9 December 2021
Rose-Anne Hawkeswood
Team Leader Resource Assessments
Department of Planning, Industry and Environment
4 Parramatta Square
Parramatta NSW 2150

We refer to your request for information dated 2 December 2021 for further information in relation to the Bulli Seam Operations (MP08_0150) Modification 3 Application:

FIGURE 1-2

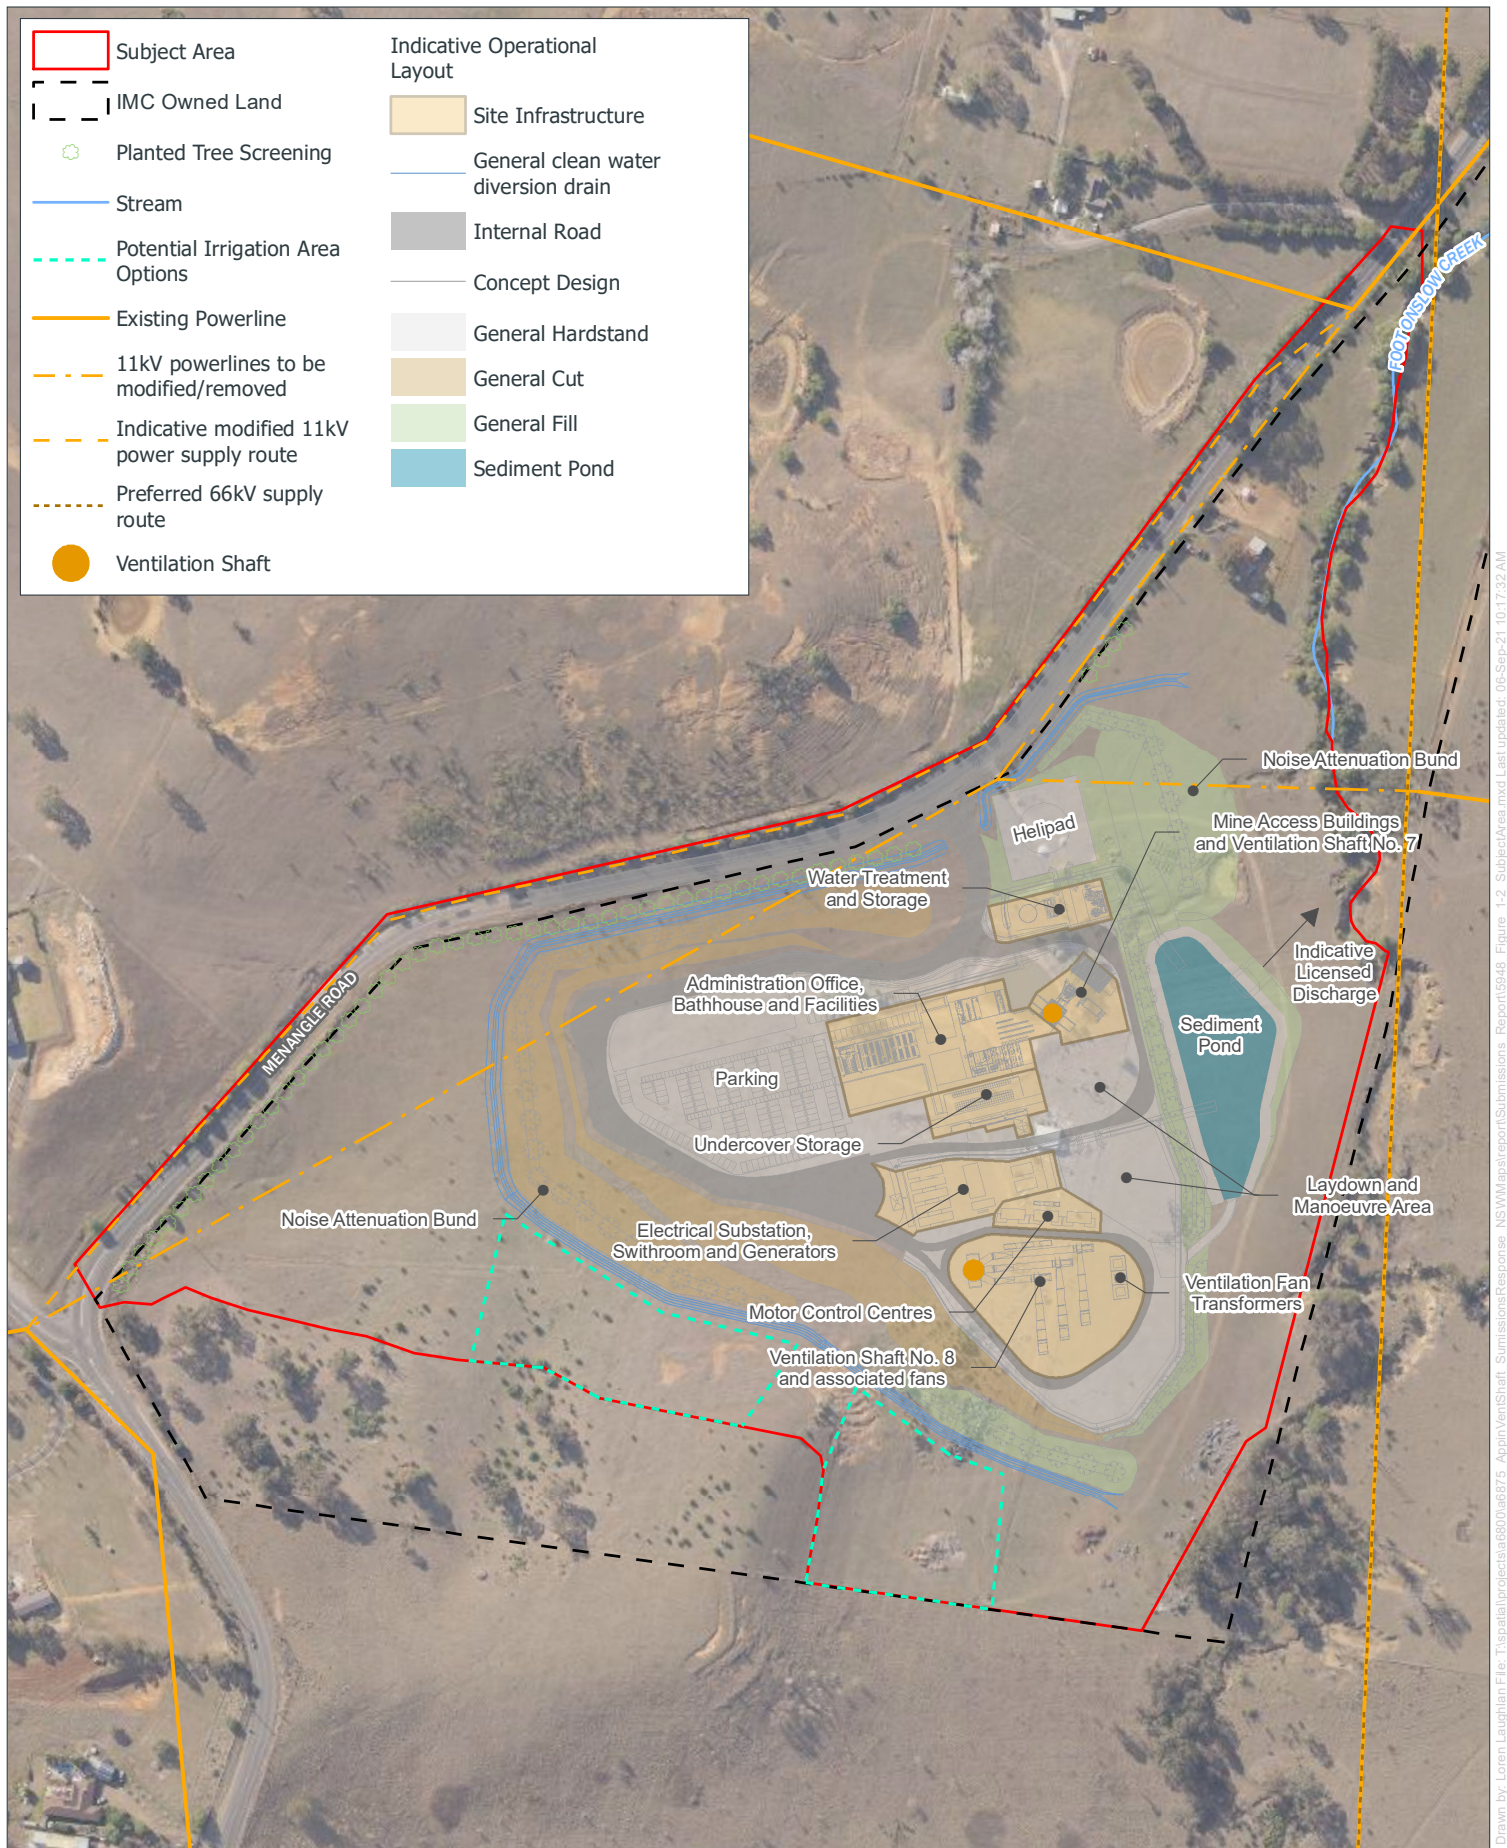
It would be appreciated if you could confirm (with justification) that there would be a safe distance between Menangle Road users and the rotor blades of any helicopters using the proposed helipad, and outline any approvals that would be necessary to operate helicopters in the area.

The operation of helicopters is not proposed as part of the Project. The construction of the Helicopter Landing Site (HLS) is proposed to provide a location for the safe landing and take-off of helicopters operated by emergency service providers in the event of an emergency (e.g. helicopters being operated by NSW Ambulance). Establishing a HLS would provide a location for the safe and swift extraction of any injured personnel by emergency services.

The concept size and location of the HLS (Figure 1-2 of the Modification Report) was designed in accordance with the Civil Aviation Safety Authority (CASA) *Guidelines for the establishment and operation of onshore Helicopter Landing Sites* (CAAP 92-2) (2014). The design aircraft used was the aircraft that is generally used to service the southern NSW region by NSW Ambulance (Agusta Westland AW139 helicopter).

In accordance with CAAP 92-2 (2014), appropriate dimensions will be applied to the Take Off and Landing Area (TLOF) to provide appropriate safety areas around the TLOF. As the HLS is designed for the aircraft to be centered on the footprint, the concept design presented in Modification Report provides greater than 30m of horizontal clearance between the proposed aircraft footprint and the Menangle Road corridor.

Further refinement of the HLS will occur during detailed design, and the final location and size will be consistent with the relevant guidelines.
